APPLICATION NO: 3/2023/0226

PARTICULARS OF DEVELOPMENT: Prior approval application for the proposed conversion/redevelopment of two agricultural buildings into two dwellings.(Resubmission of 3/2022/0436)

AT: Land adjacent to Miles Hill Moor Lane Billington BB7 9JH

Ribble Valley Borough Council hereby give notice the prior approval of the authority is **REFUSED** for the carrying out of the above proposal for the following reason(s):

SHEET: BARN 1 EXISTING AND
PROPOSED PLANS AND
ELEVATIONS

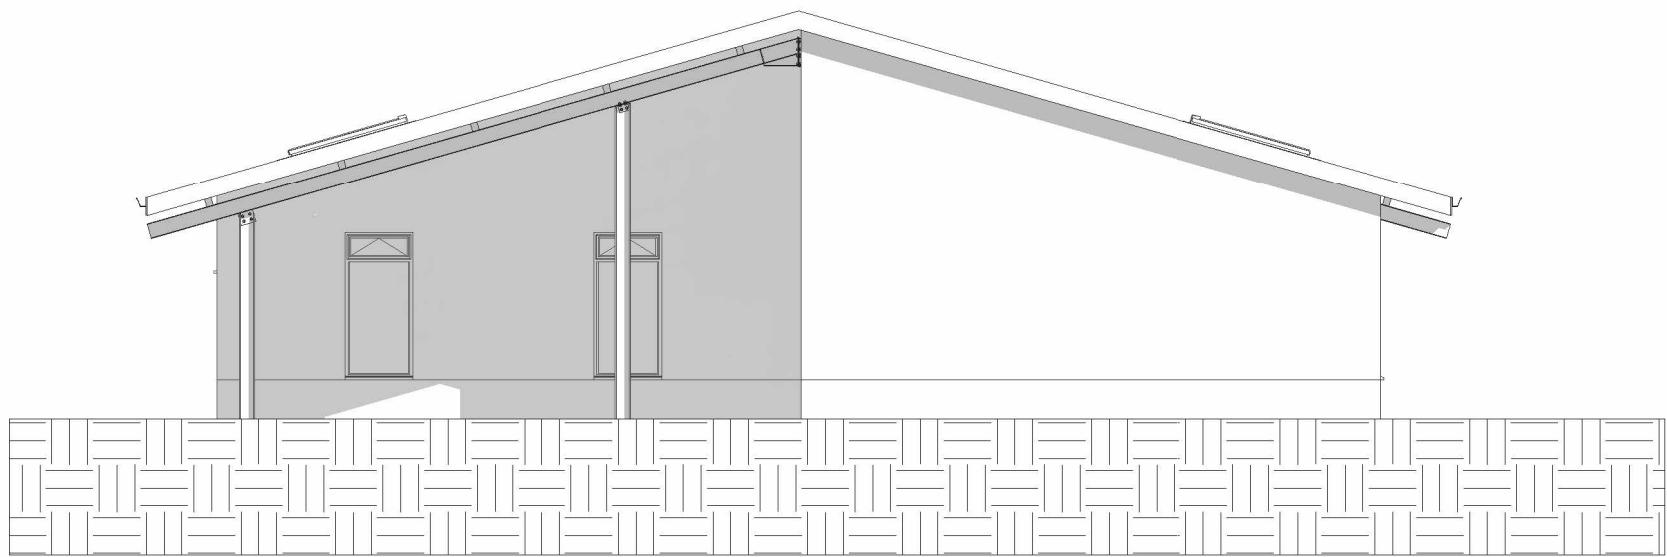
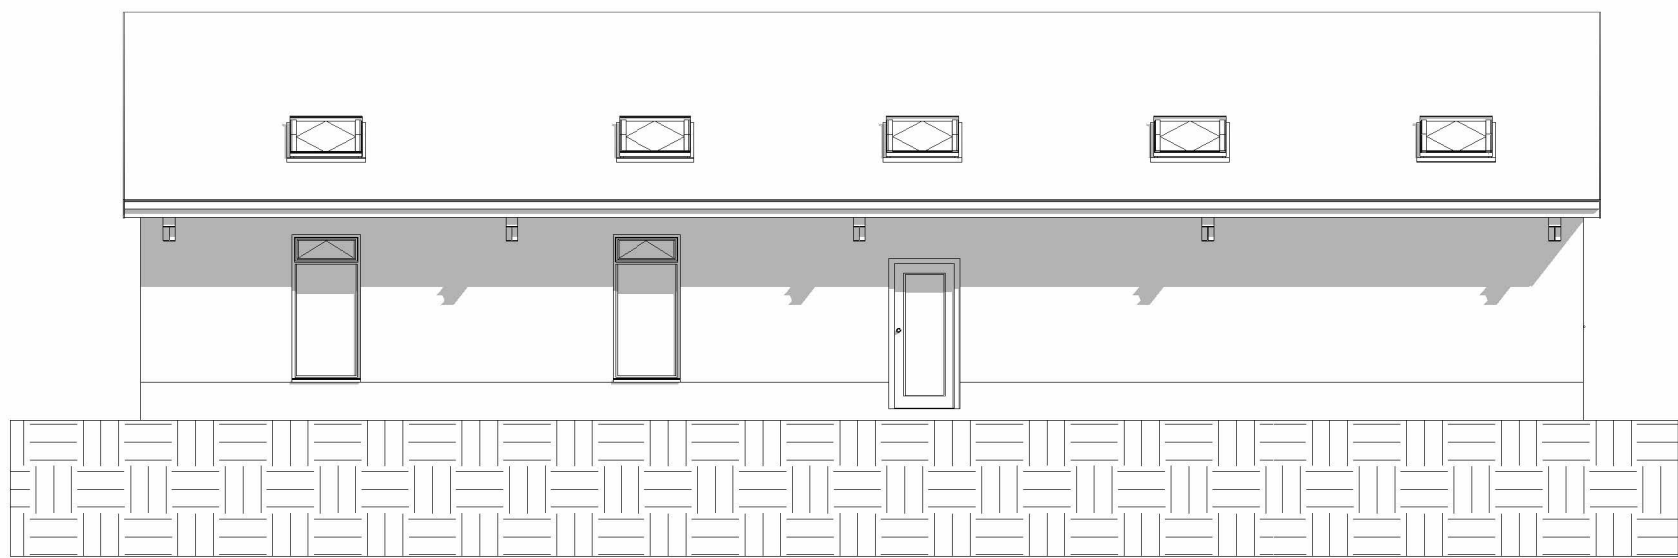
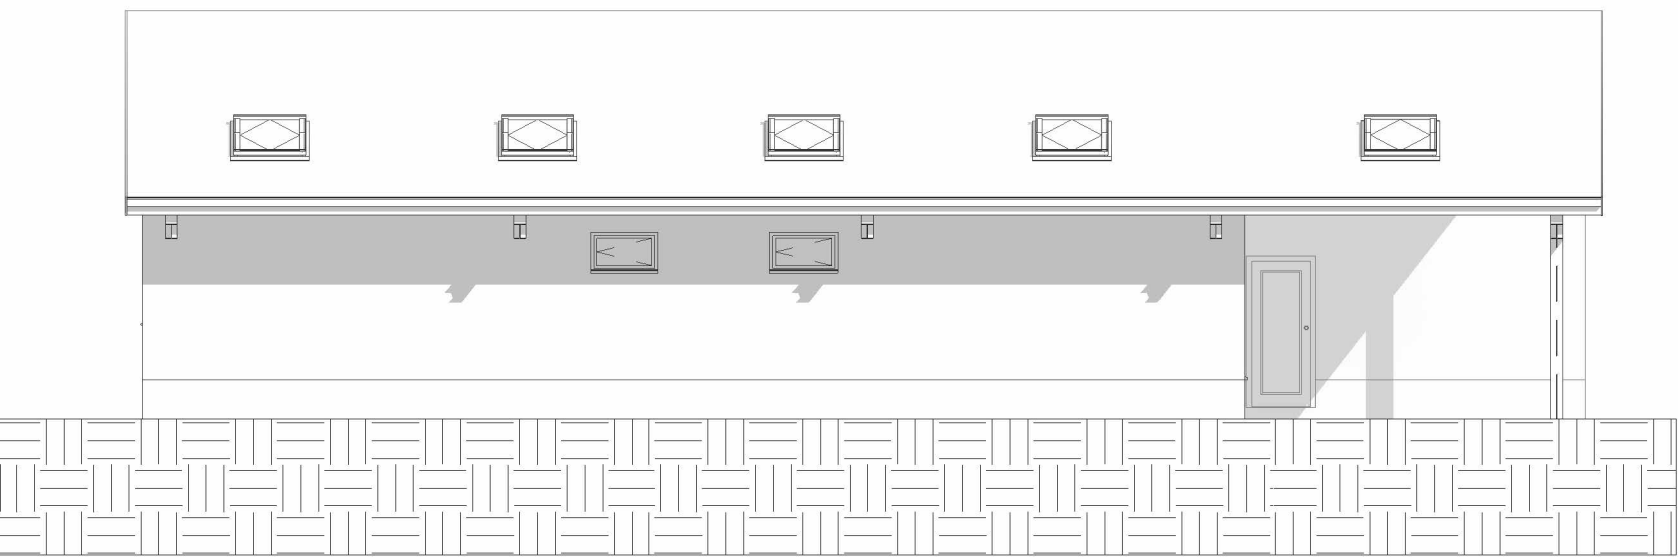
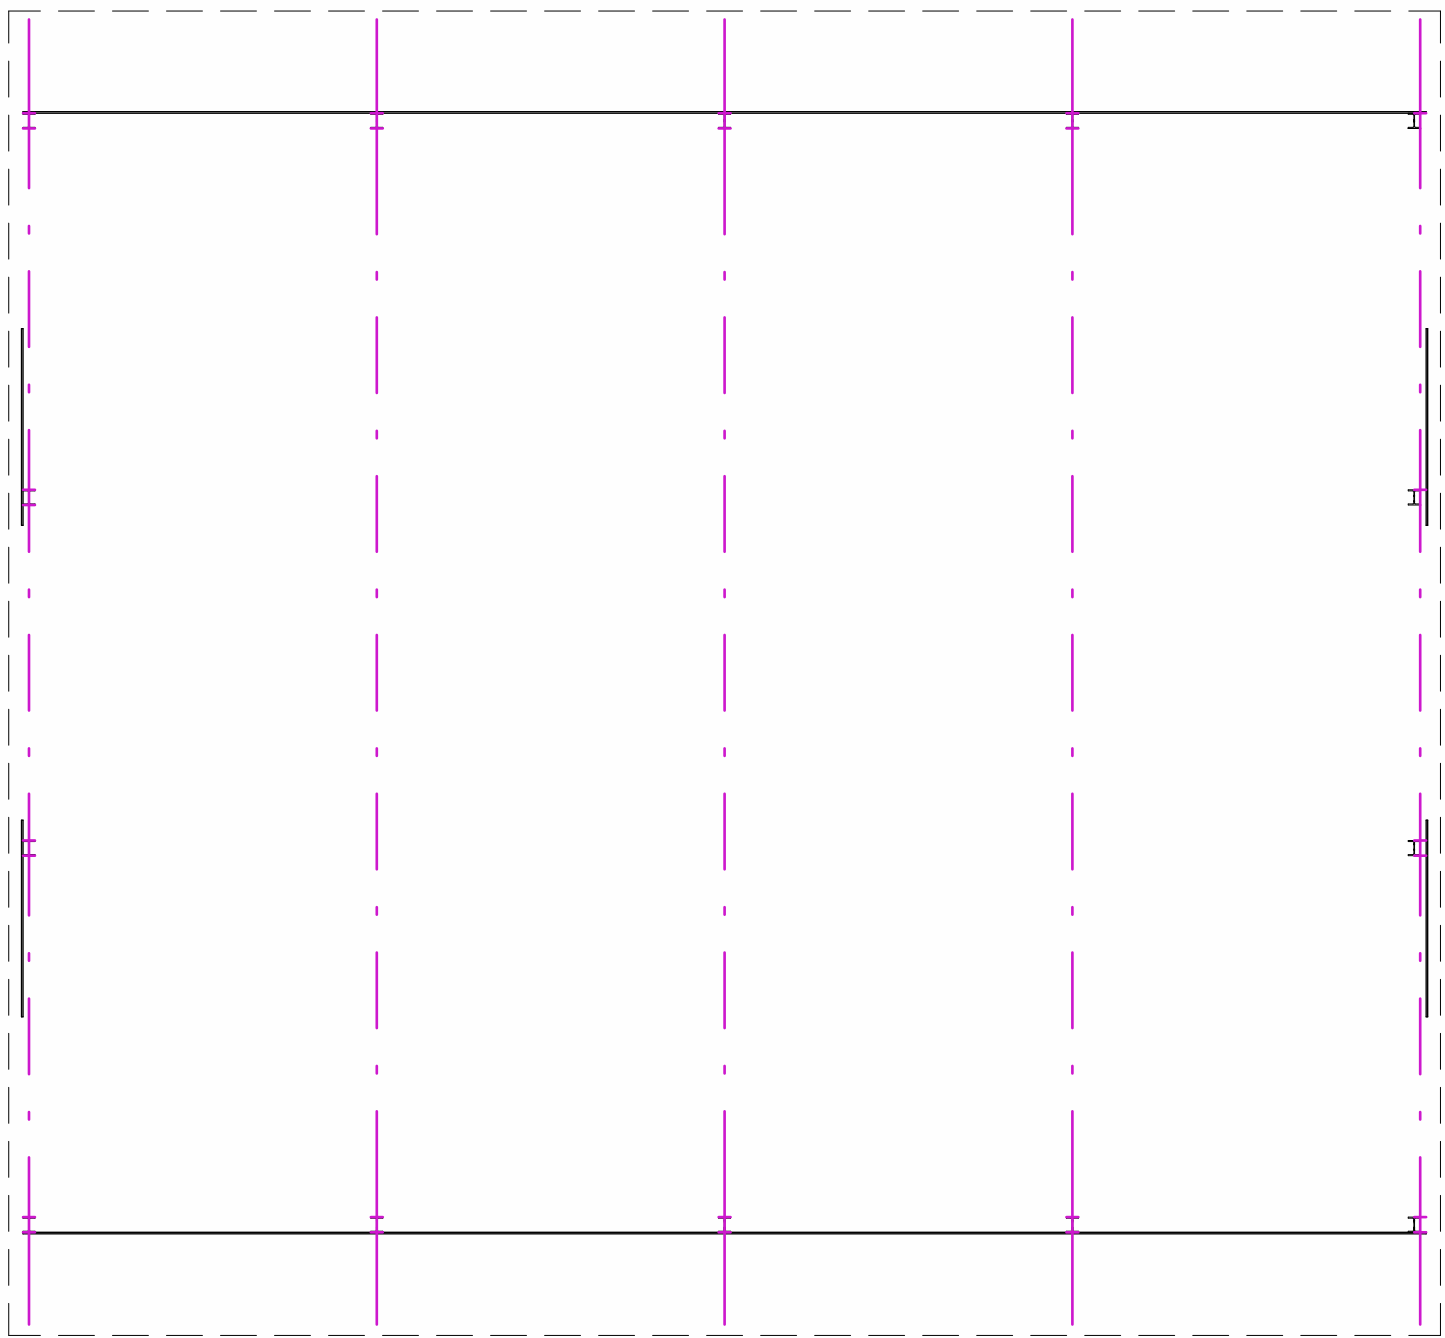
2. The design and external appearance of the development would adversely affect the character and appearance of the buildings and the surrounding countryside. The proposal would fail to comply with paragraph 130 of the National Planning Policy Framework and policy DMG1 of the Ribble Valley Core Strategy. It would therefore fail to satisfy Schedule 2 Part 3 Class Q 2 (1) (f) of the Town and Country Planning (General Permitted Development) (England) Order 2015 (as amended).

PROPOSED SITE PLAN

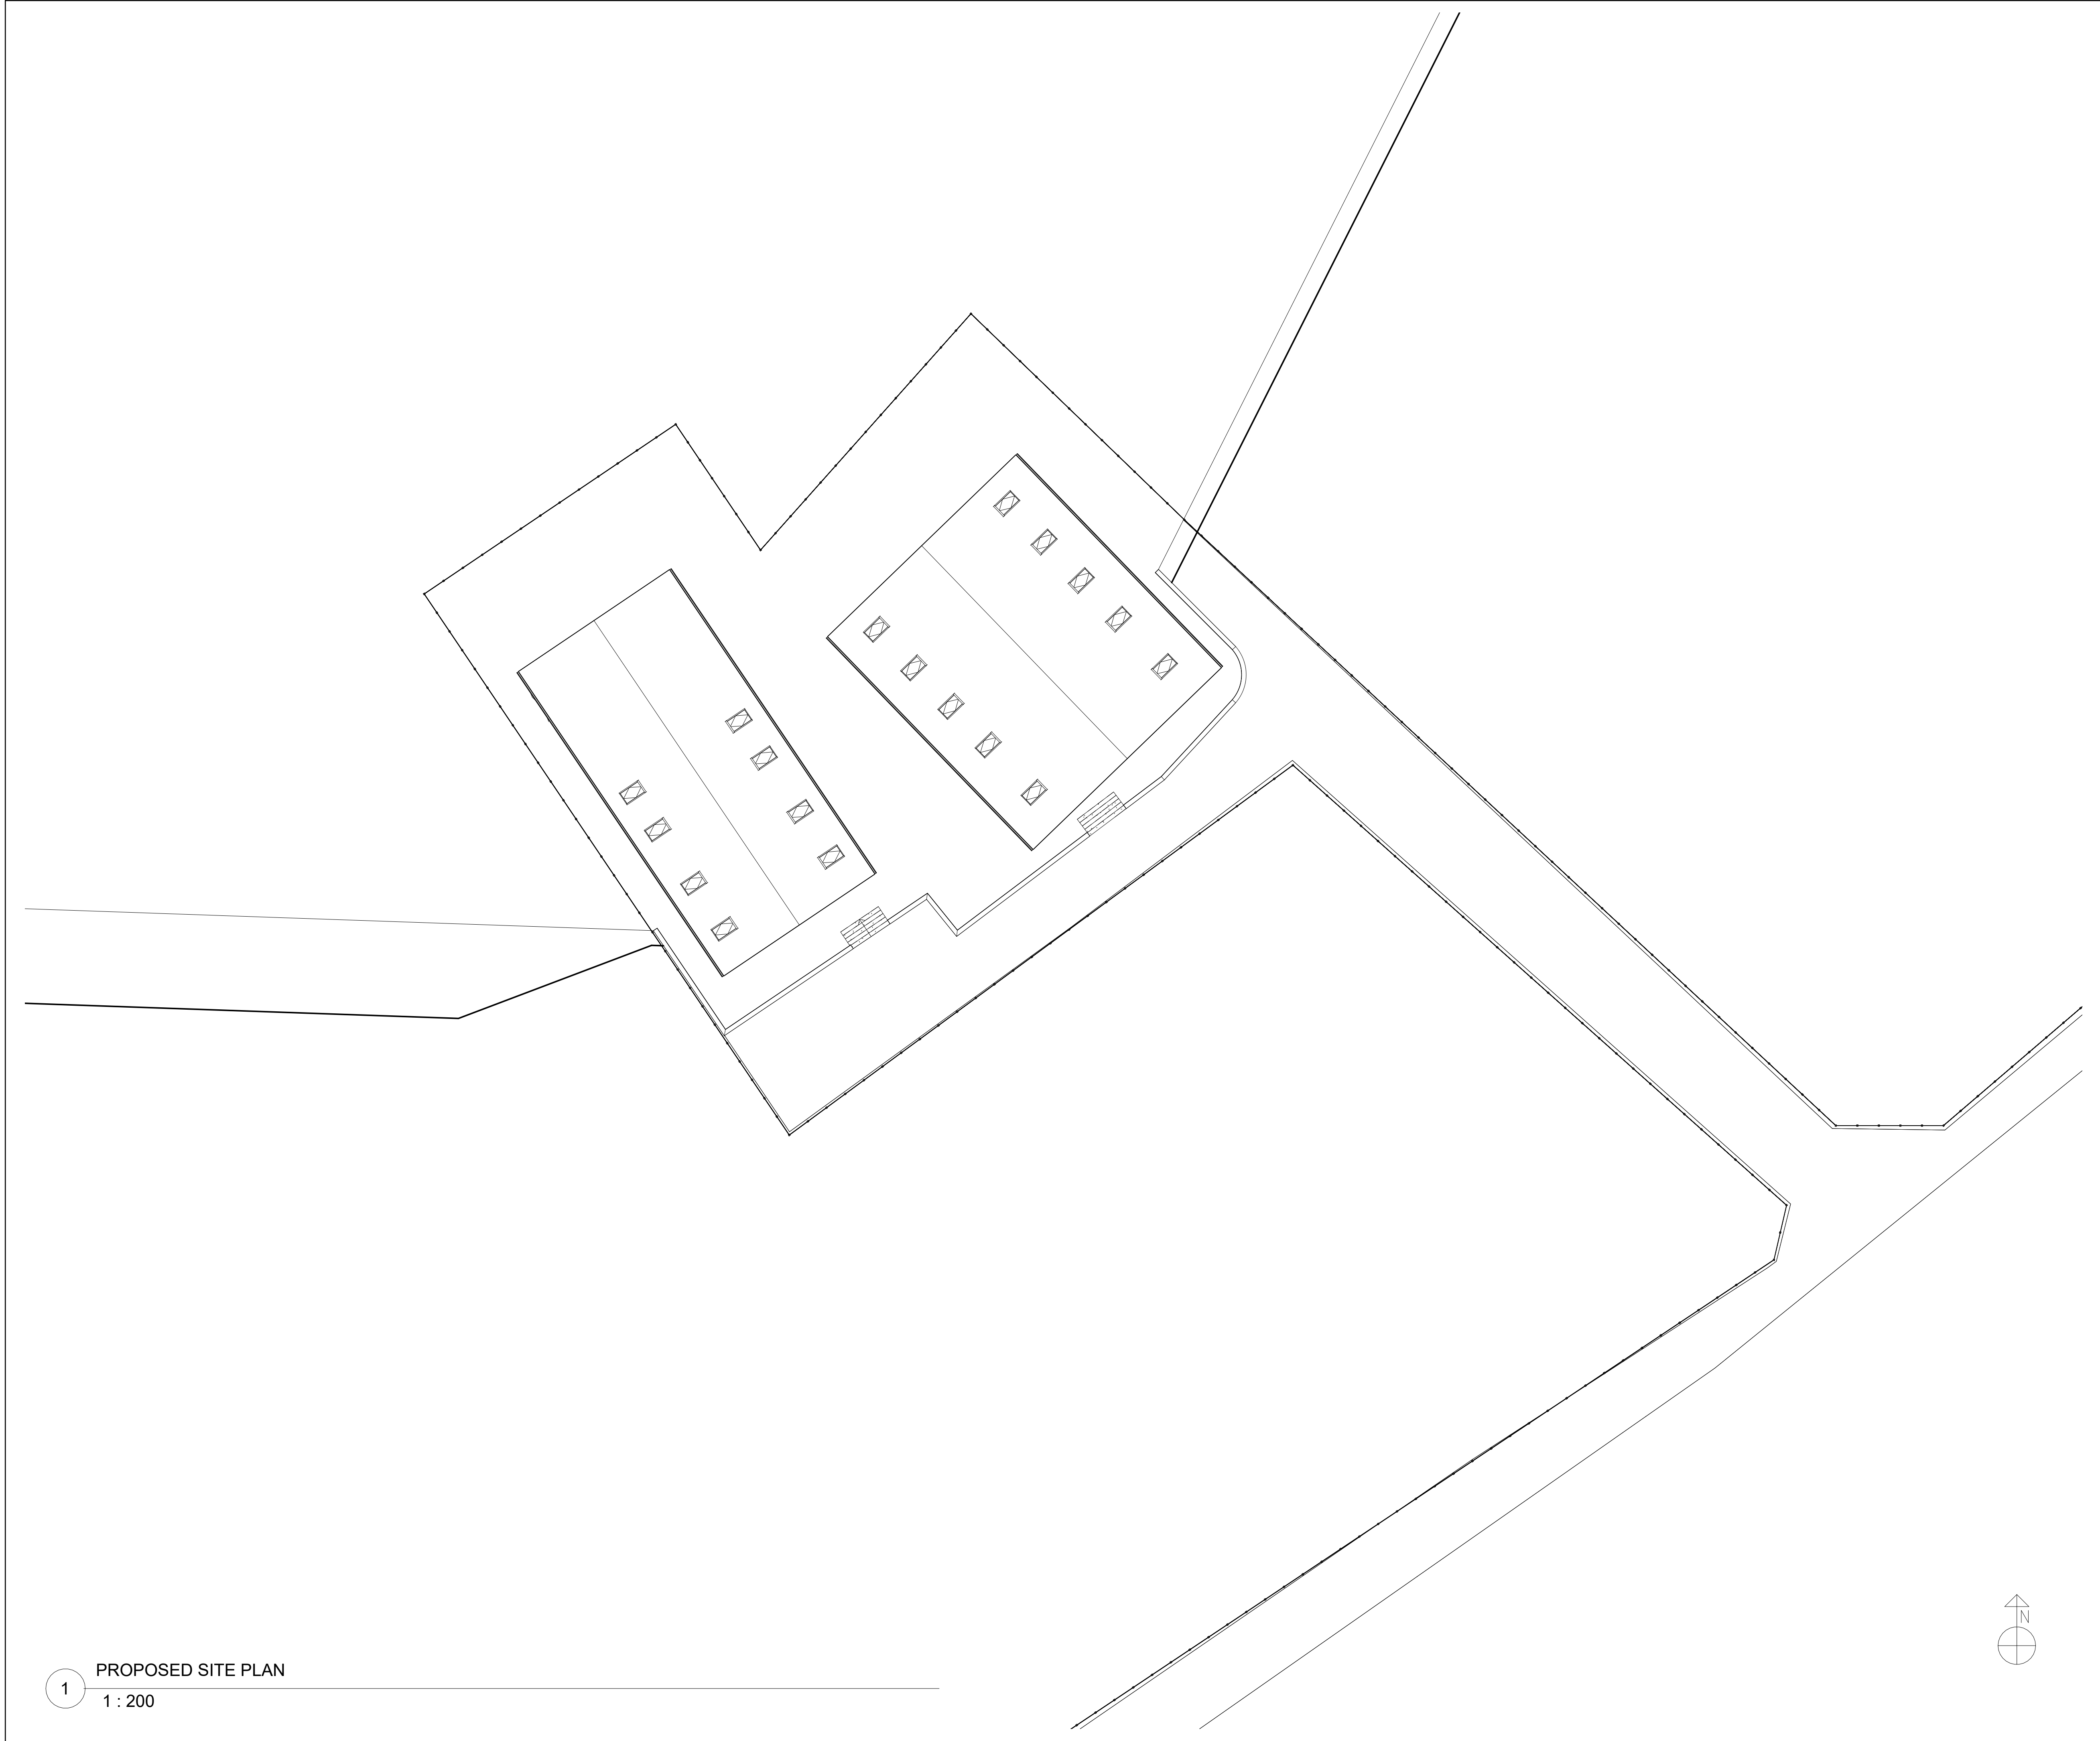
1. The development fails to satisfy Schedule 2 Part 3 Class Q of the Town and Country Planning (General Permitted Development) (England) Order 2015 (as amended) in so far as the development consists of building operations that are not considered reasonably necessary to convert the buildings, namely the provision of retaining wall structures and change in land levels shown to the front of the buildings.
